Permit Number: 050152

This is to certify that Mccain Mark /Owner
has permission to Interior and exterior renovation inc. Roof deck access
AT 69 State St 044 G004001

Re: 69-71 State Street – exterior alterations and additions

69 STATE STREET, PORTLAND
 GROUND FLOOR
 1/4" = 1'

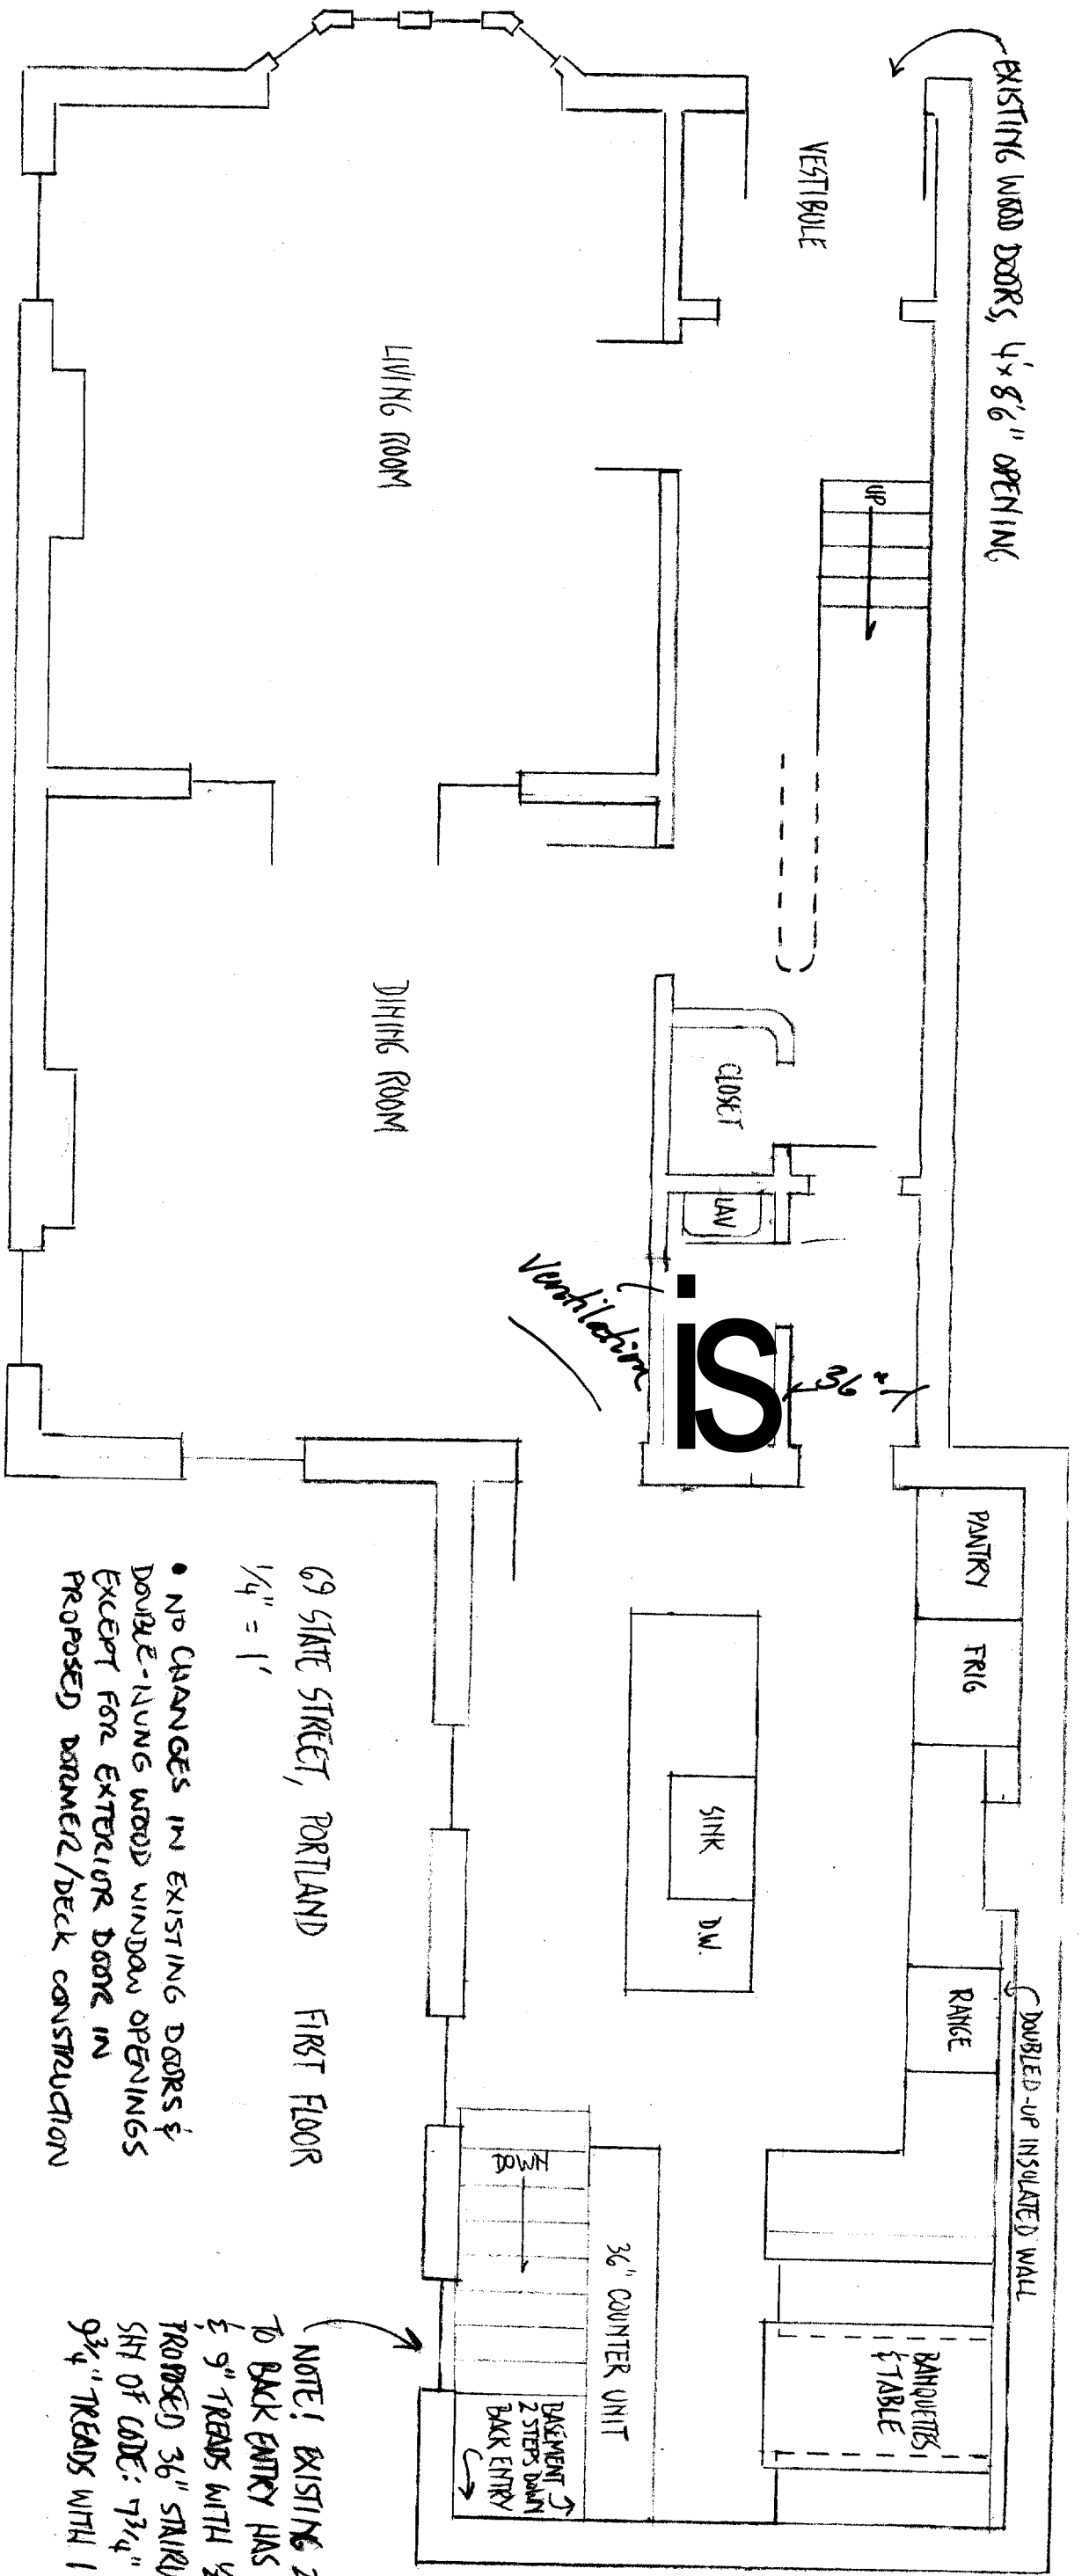
- 1) As discussed, hardwired interconnected battery backup smoke detectors shall be installed in all bedrooms, on every level, and in a common area.
2) Permit approved based on the plans submitted and reviewed w/owner/contractor, with additional information as agreed on and as noted on plans.
3) Separate permits are required for any electrical, plumbing, or heatmg.
4) Application approval based upon information provided by applicant. Any deviation from approved plans requires separate review and approval prior to work.
